1.0 Review of revised development proposal - Everest House

1.1 Observations on July 28th application with sealed windows to south facades

Mike Stigwood, Lead Consultant and Director
MAS Environmental Ltd.

9th September 2020

02 Proposed Ground and Typical Floor Plan
1:200 @A3

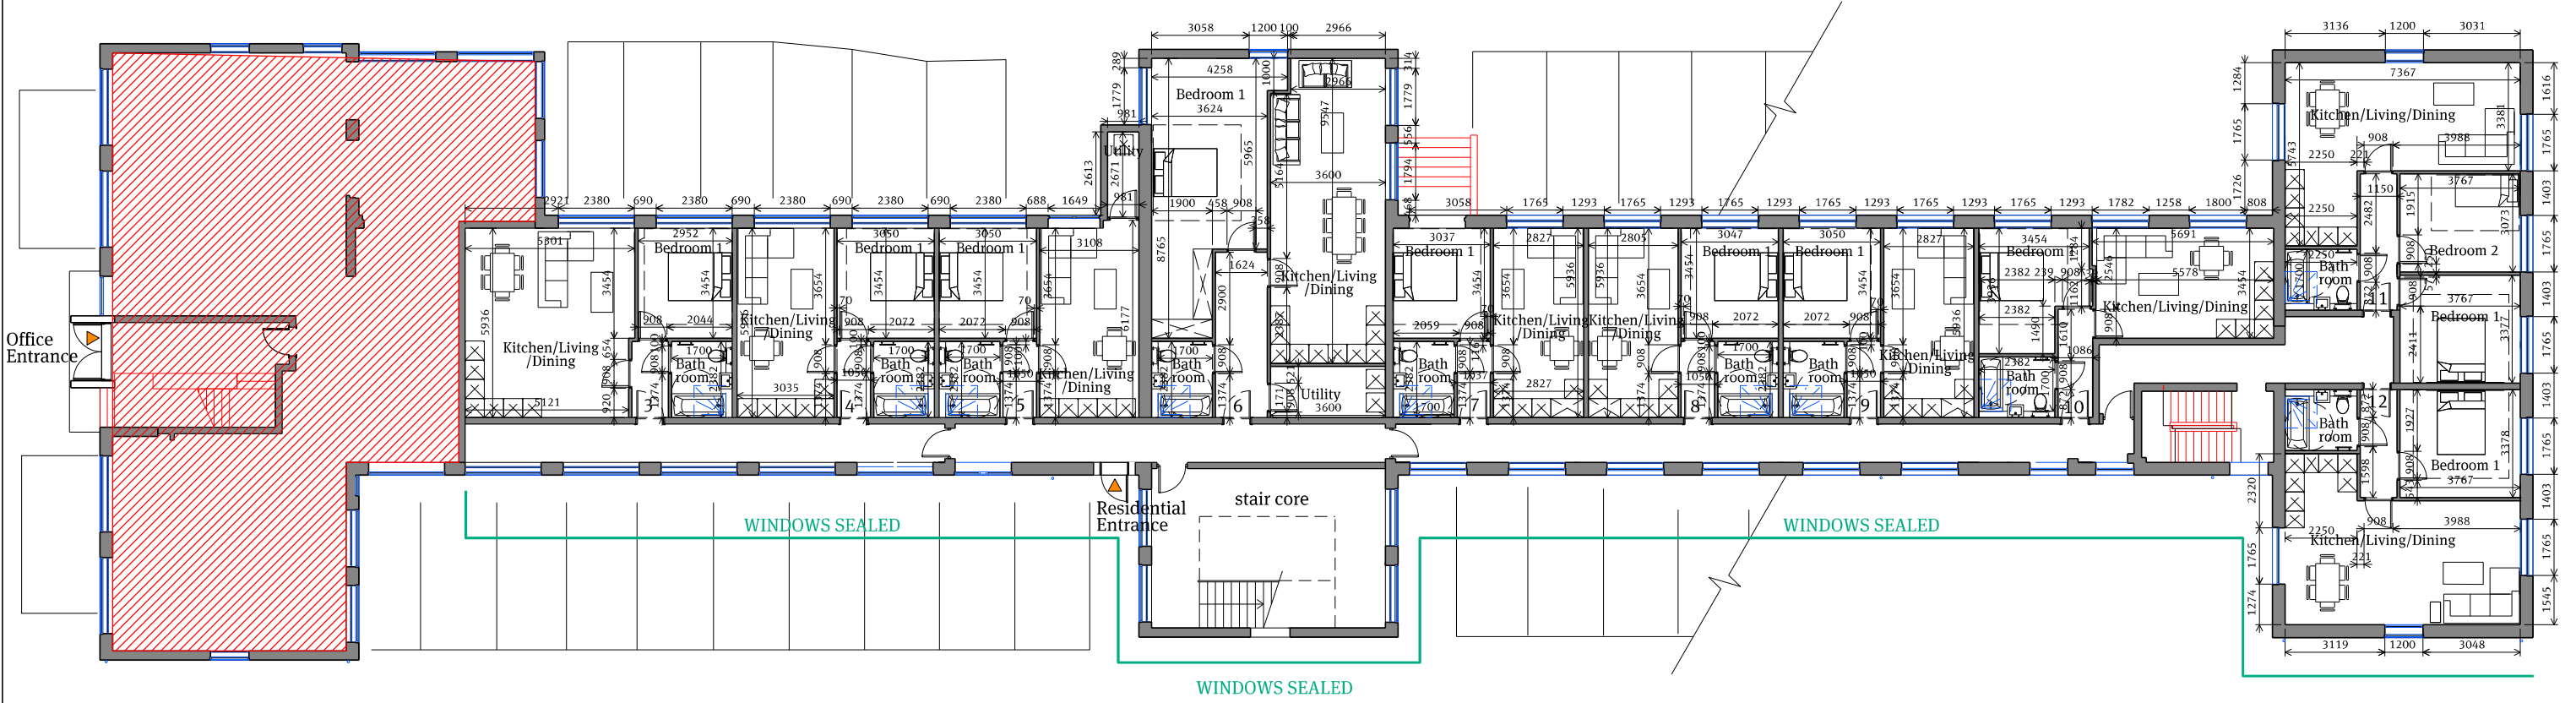
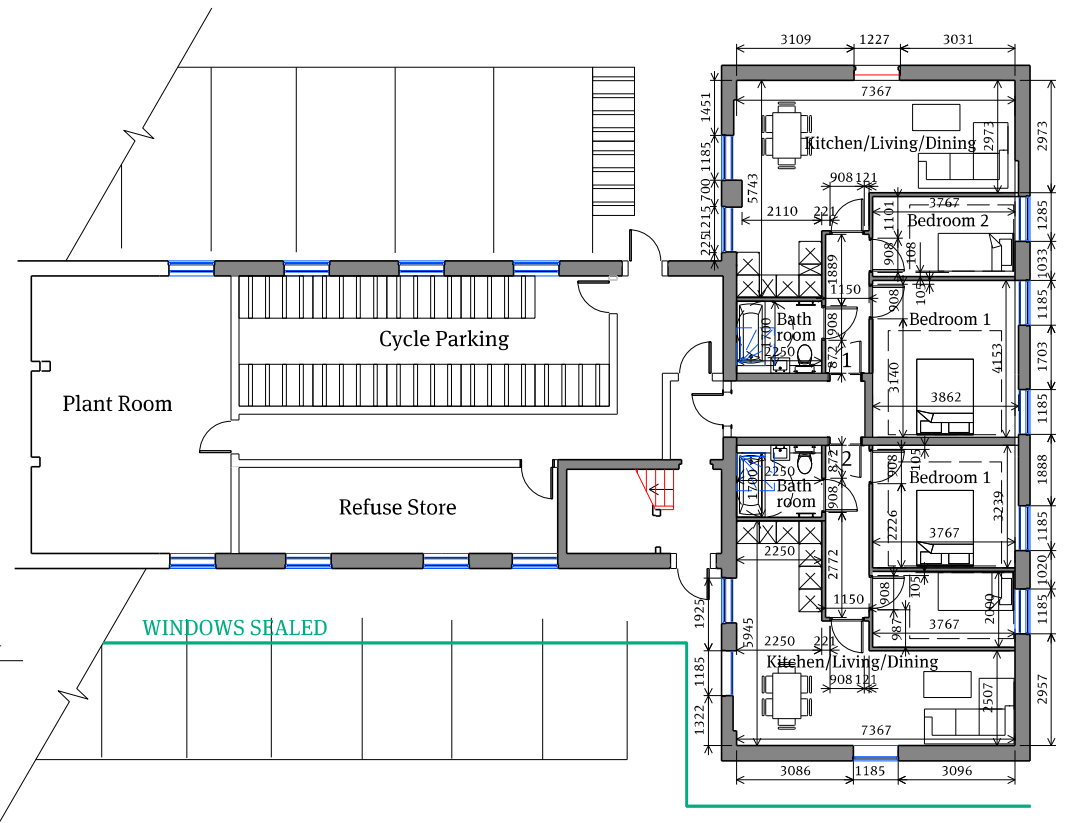
- 1.10 It is to be recognised this introduces a lower quality of living but in most cases includes a corridor which acts as a single aspect form of development. Unfortunately, there are some exceptions. It is noted this relates to the southern facades and operable windows are provided either to north or east facing facades.

- 1.11 A critical issue here is the ability to be able to enforce as a constraint the alteration of windows to prevent them being rendered operable. In some cases, operable doors can be an issue but there is not evidence in the proposals that this will be an issue. There would need to be a condition preventing the alteration of facades and windows. This is not readily policed in the future.

- 1.12 A clear specification is required of windows so it can be determined their sound reduction is adequate in all frequency bands. One adverse effect of acoustic glazing can be the excessive reduction of mid and higher frequency sounds but continued penetration by low frequency sources. There has been no assessment of this potential issue other than two stated values and these are rejected as insufficient. There is no provision of spectral information on sources of noise.
